March 3, 2016

RE: North I-25 Corporate Center (File: B18D001)
Response to comments for the Amended Drainage Master Plan dated 11-4-2015

**EXISTING BASIN MAP**

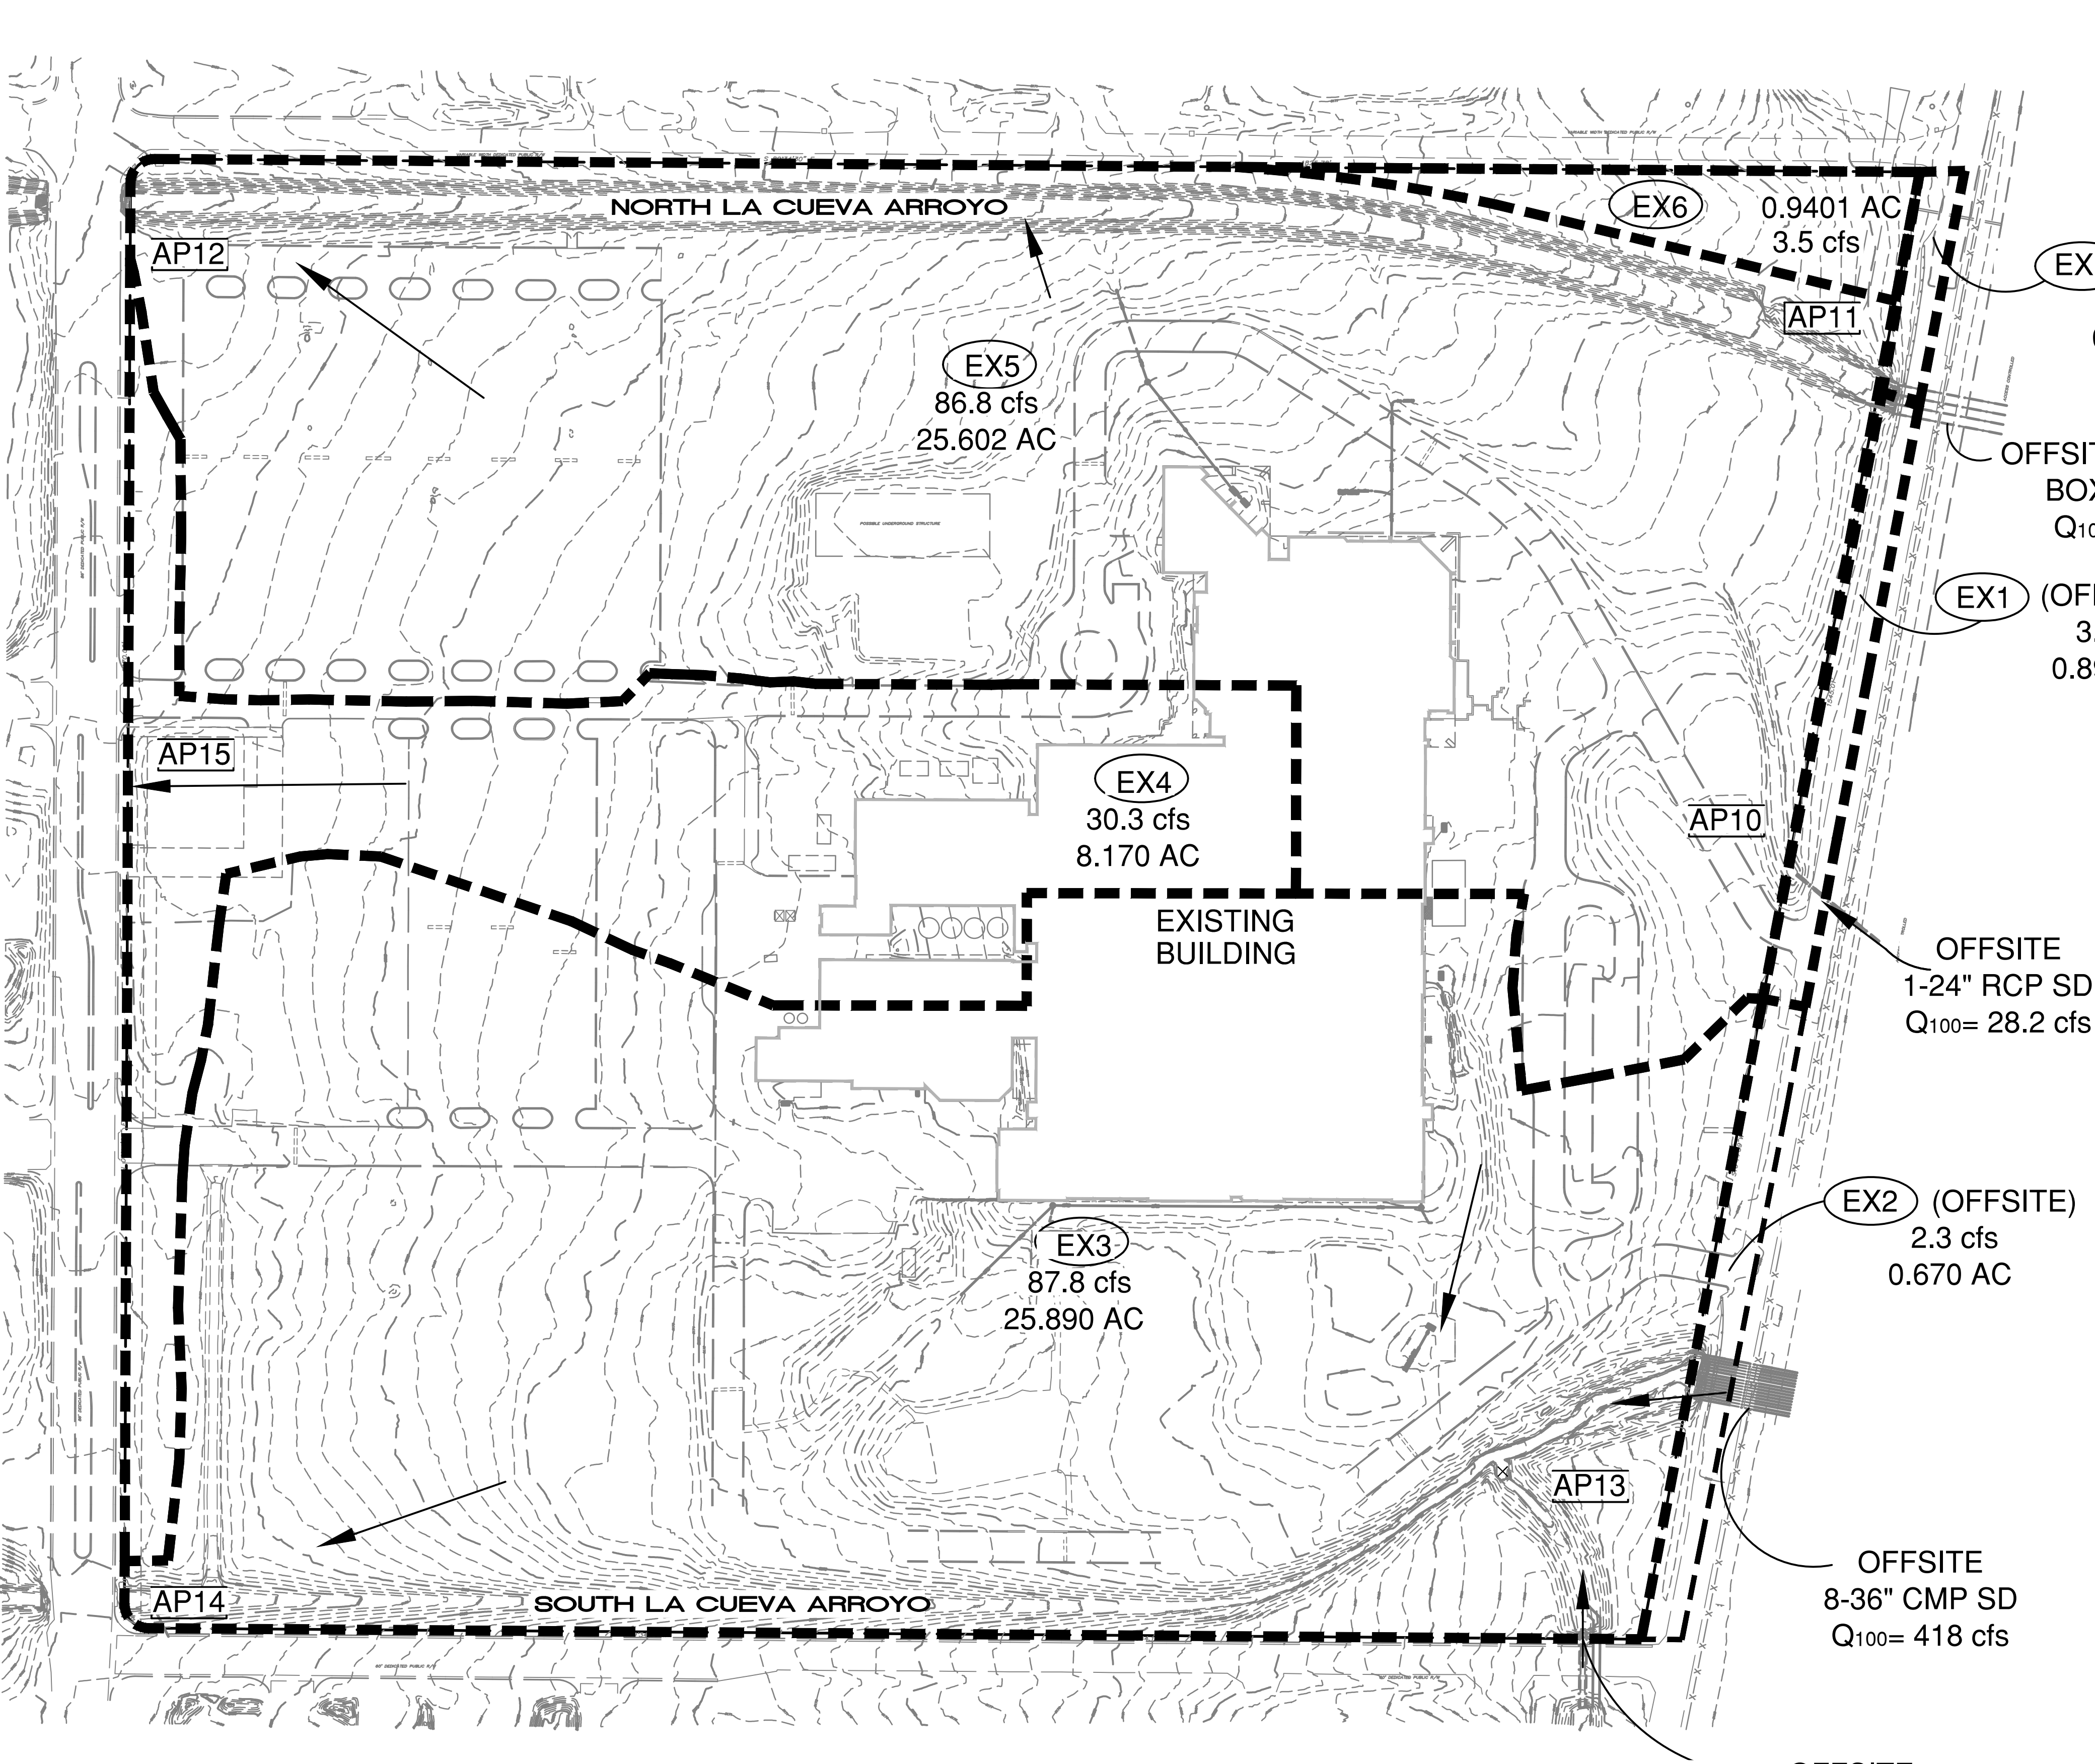
- c. The Former Coronado Landfill Excavation As-Built is included in Appendix A.
7. A current plat is included in Appendix A.
8. Based on the COA GIS map site's 2014 aerial and most recent google maps, the area has not changed in any significant way. The equipment sales lot and undeveloped land are still on the north side of Modesto Ave. There's an unpaved industrial lot and the cemetery to the south. Modesto Ave appears to still be in the same condition. The basins have not changed. I've added the linework (as much as can show at the same scale) to the existing basin map.

**PROPOSED BASIN MAP**

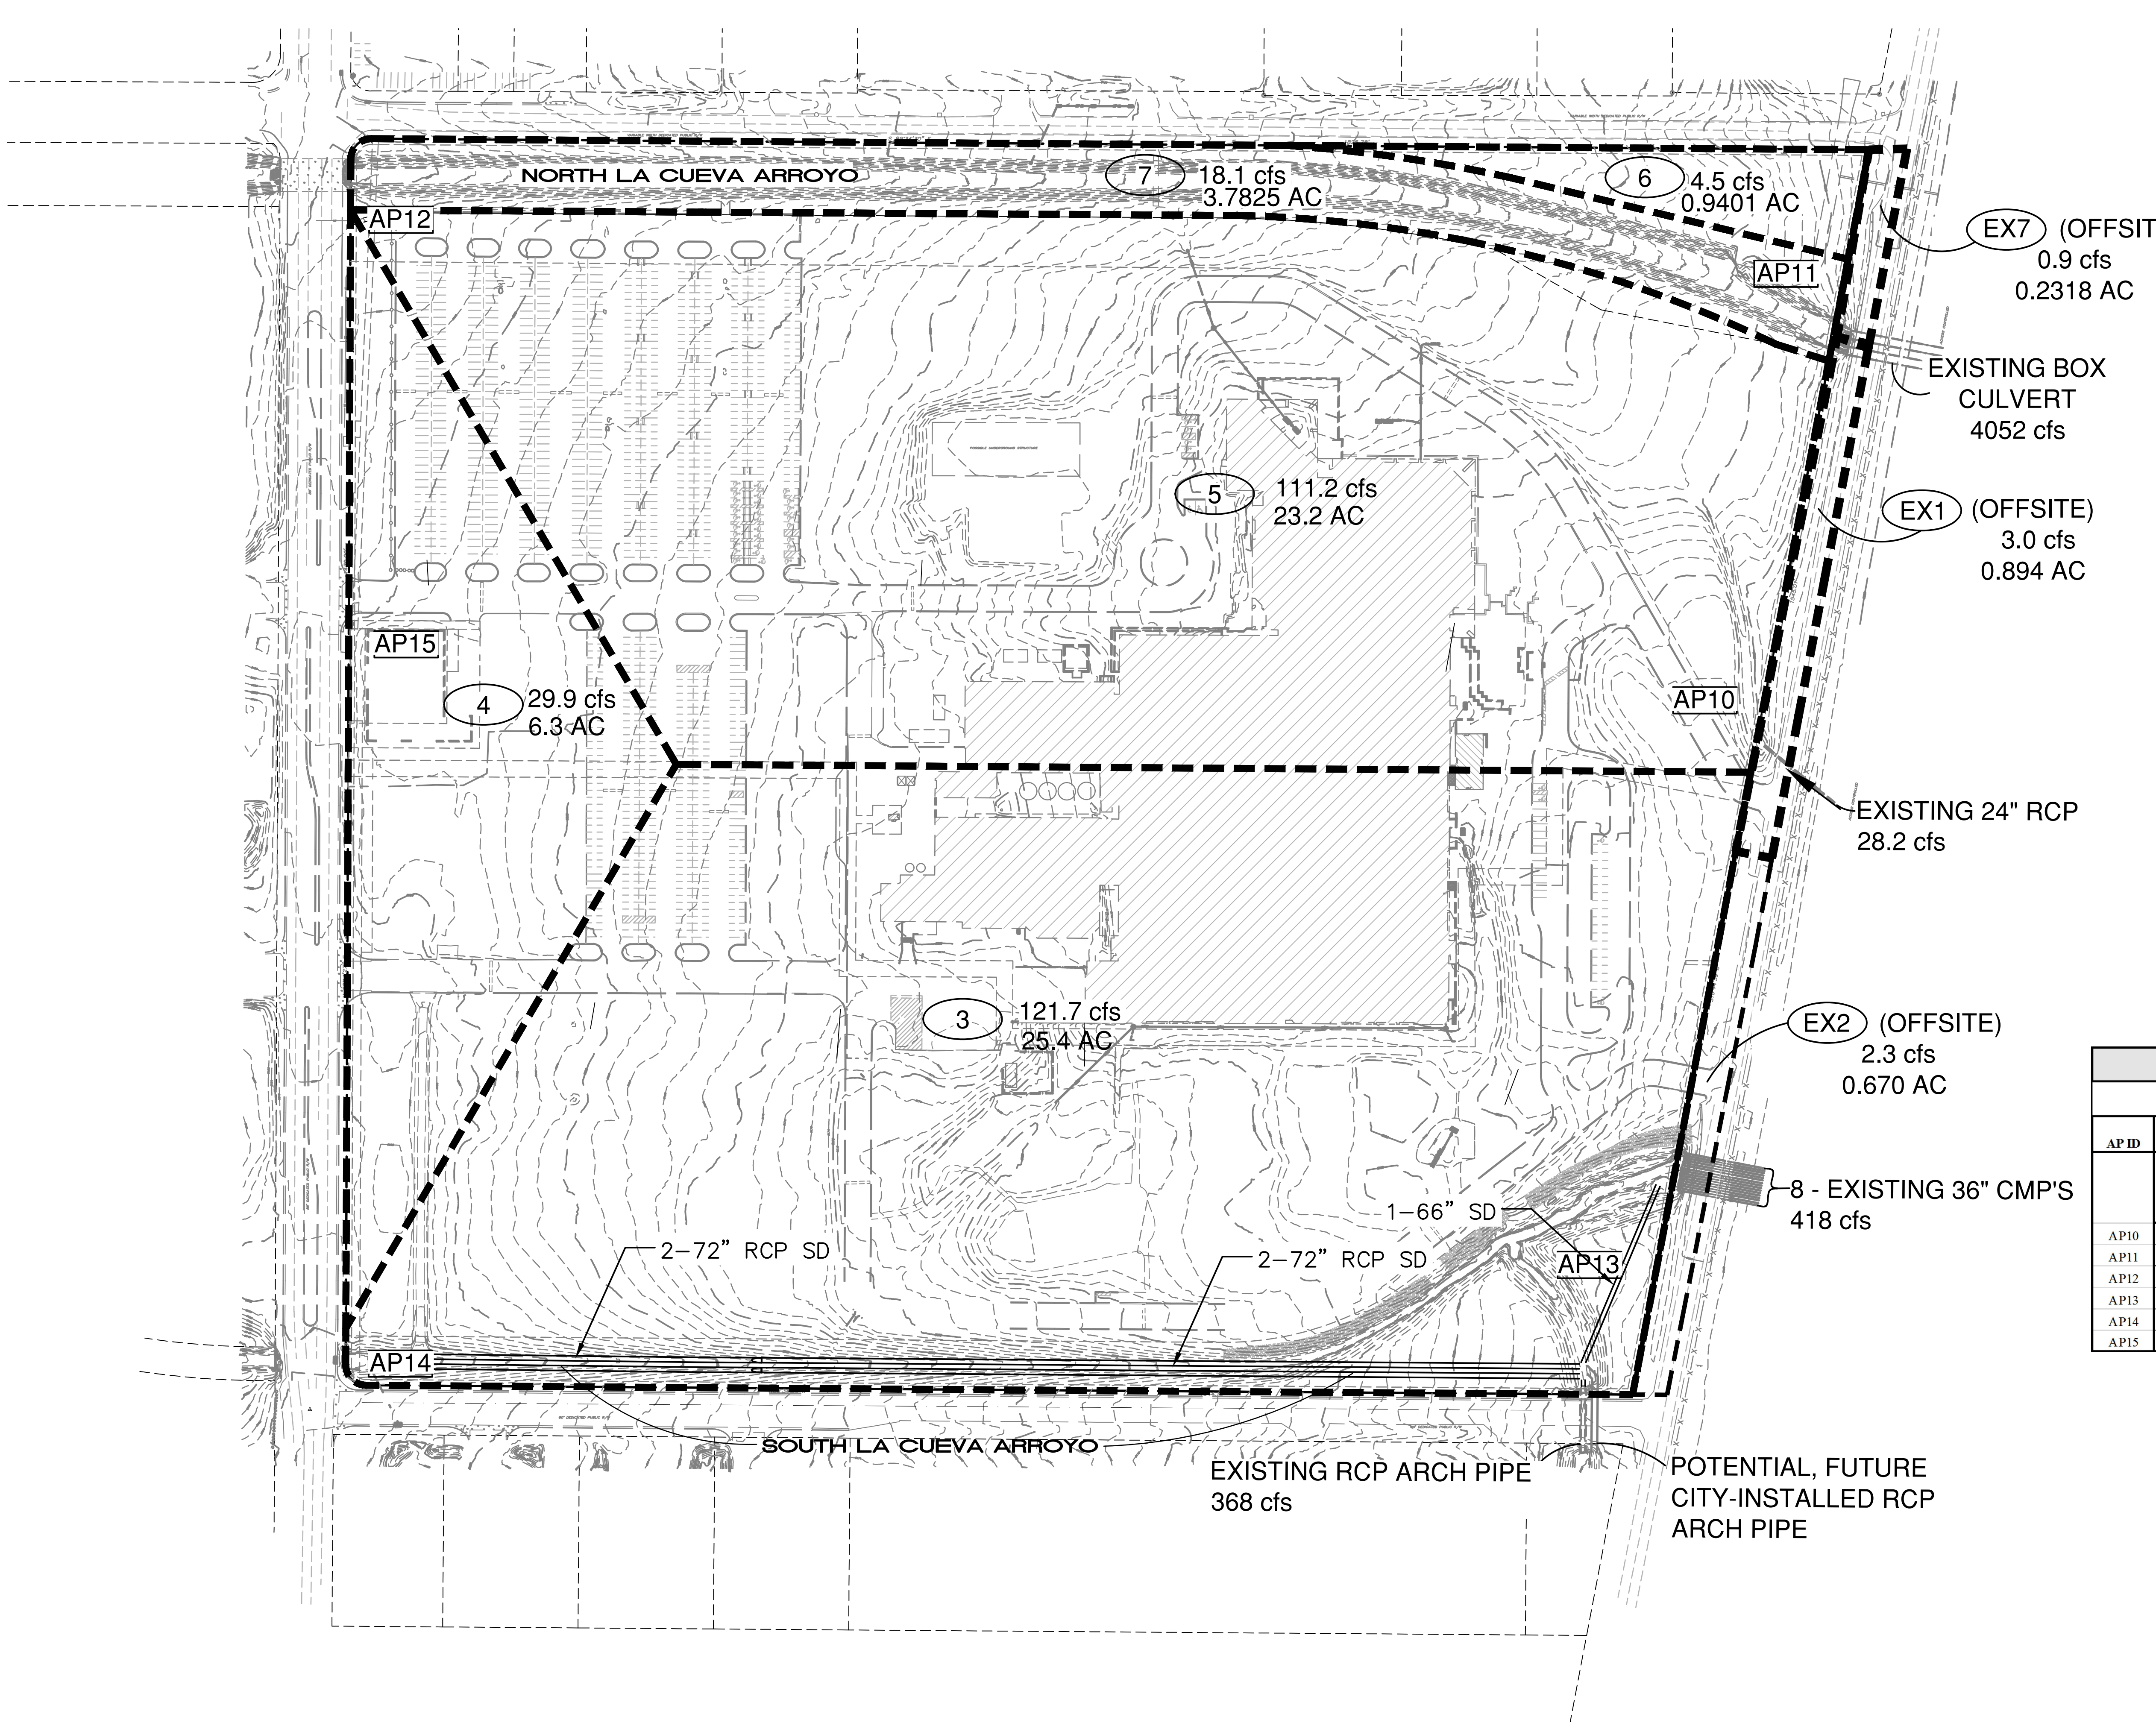
12. The basin boundary plan in the DMP we're amending matched the old Site Development Plan for Subdivision. The plan before EPC for the Broadstone project on the southwest corner is requesting that the old SDP be amended, and it is likely that future developments will change the SDP again. The purpose of this Amended DMP is to clean up the basins so that they are more generic and don't match the old SDP layout.

The conceptual drainage plan for the Broadstone project was created after I submitted this Amended DMP. The deviations from the generic basin boundaries in the Amended DMP were addressed in that conceptual grading plan. The area west of Broadstone is outside the limits of that project. That area will continue to drain as per historic conditions.
